**PLANNING & COMMUNITY DEVELOPMENT
DEPARTMENT**

February 12, 2020

RE: Templeton Gap Townhomes
File: CPC PUZ 20-00012, CPC PUP 20-00013, CPC PUD 20-00014, AR FP 20-00054

### LIGHTING PLAN

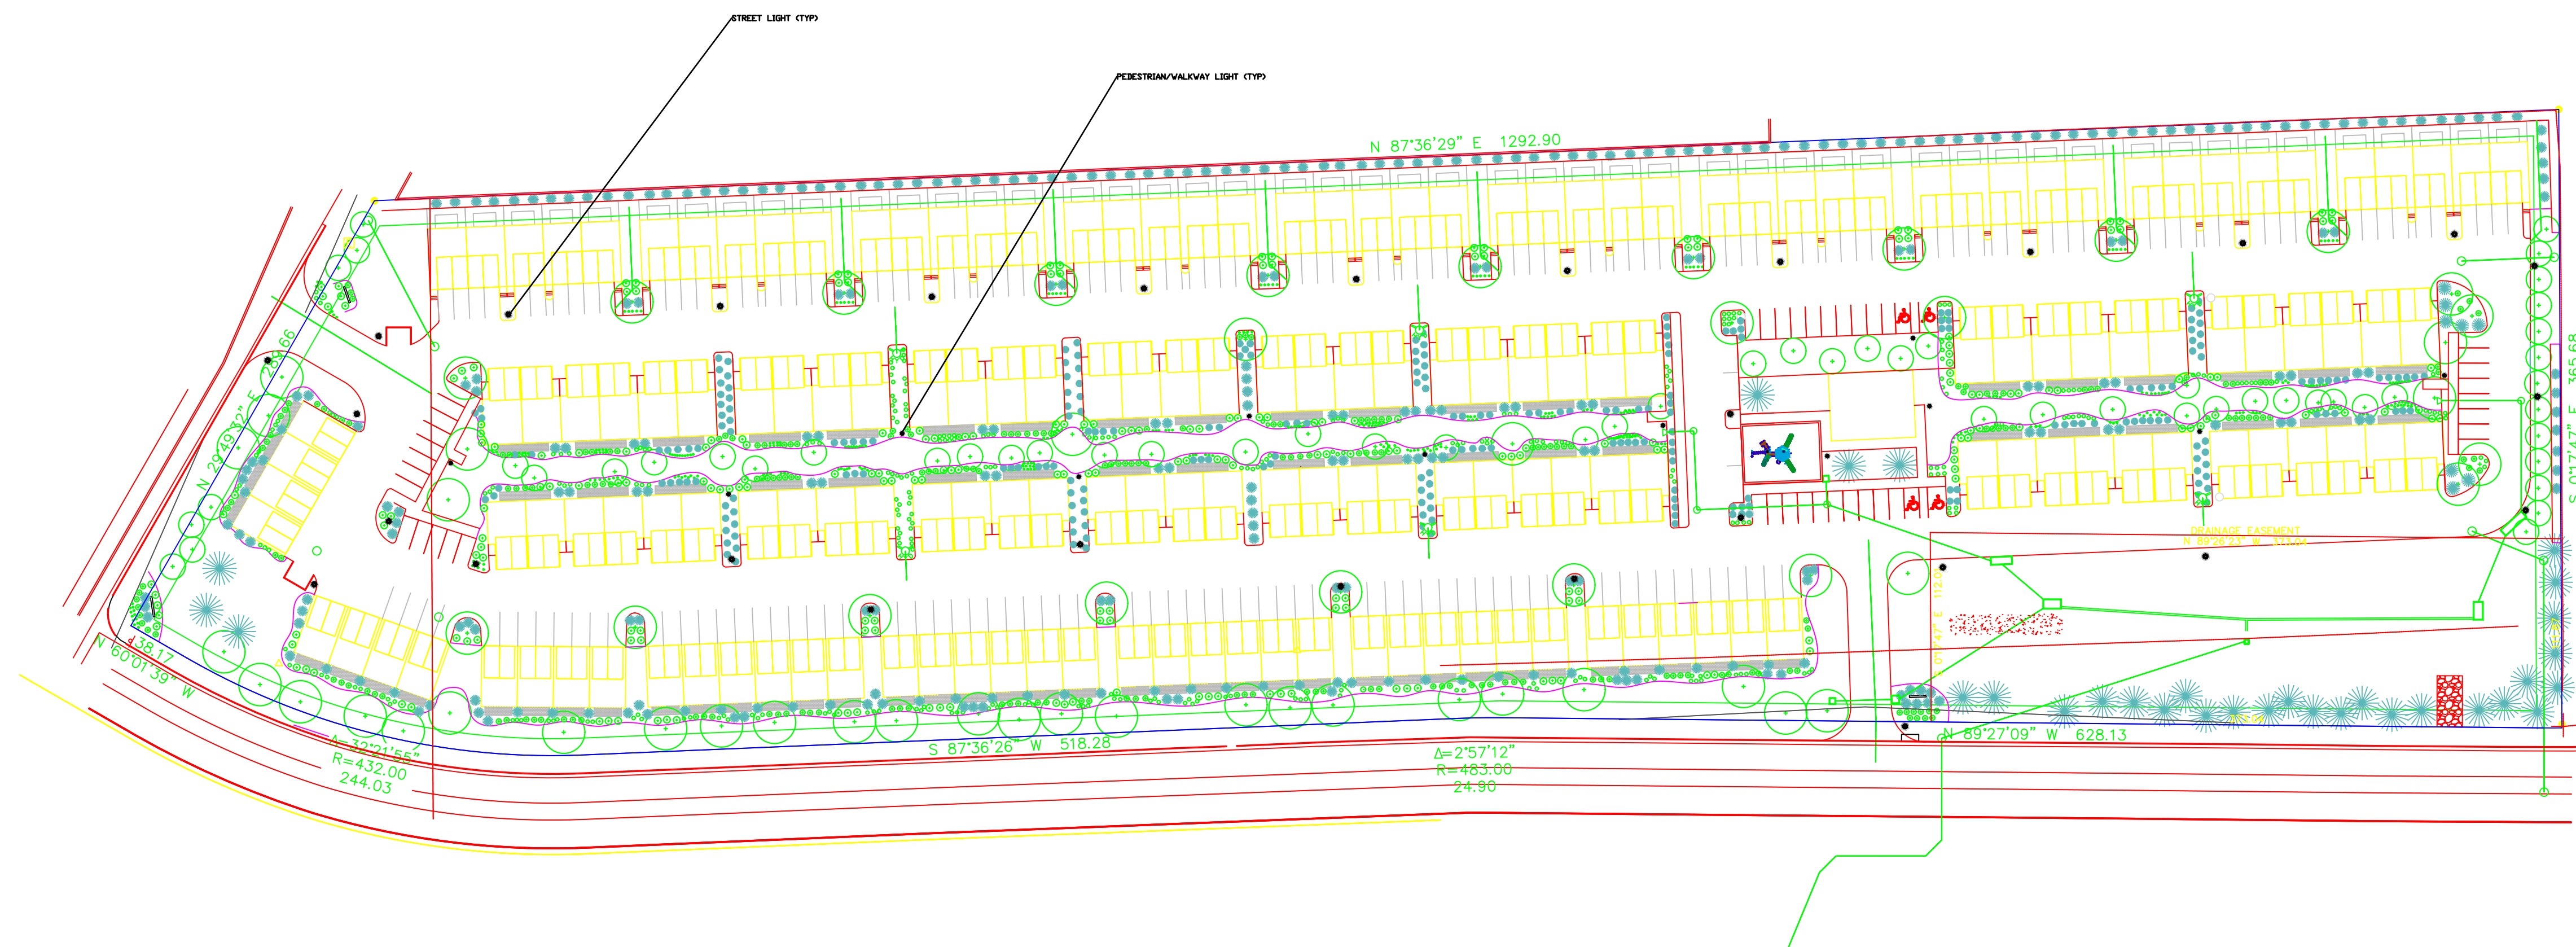
22. On the lighting sheet, is the proposed fixture full cutoff?

Figure 9
Conceptual Pedestrian Crossing
Galiant Townhomes (LSC #194450)

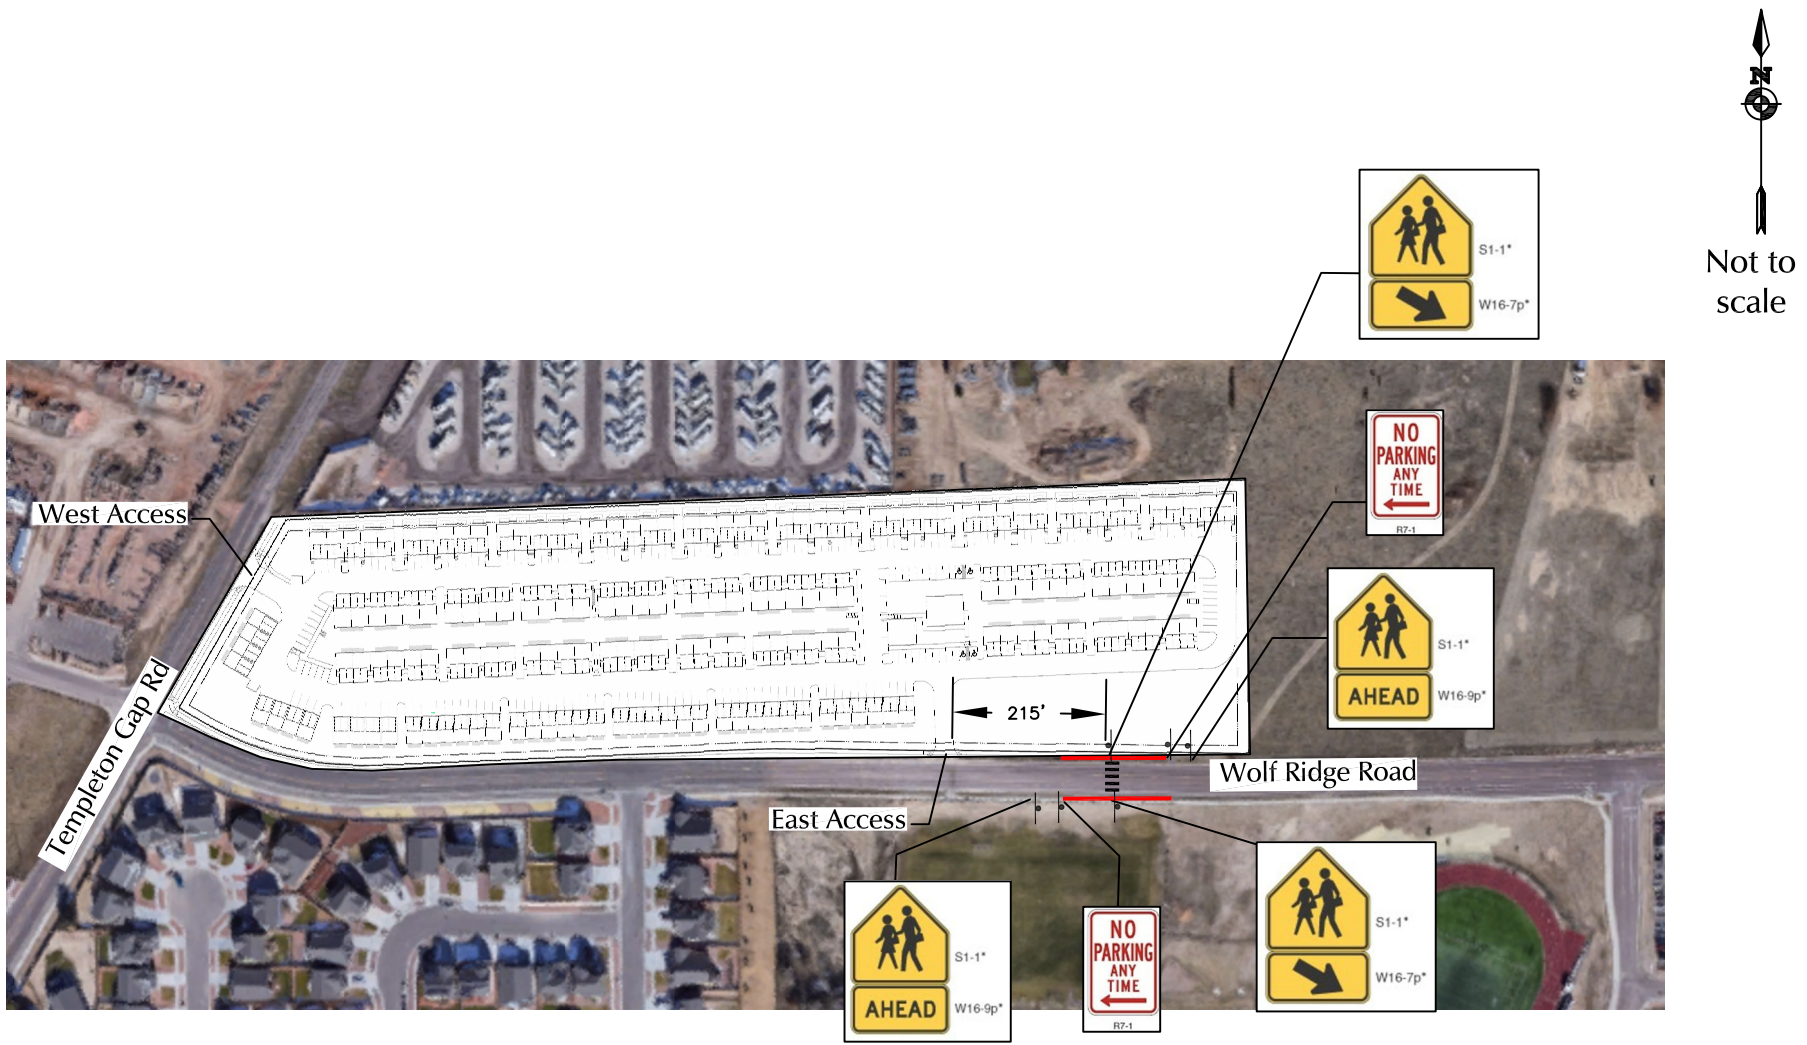
3- Please analyze a pedestrian crossing location to Vista Ridge High school campus.
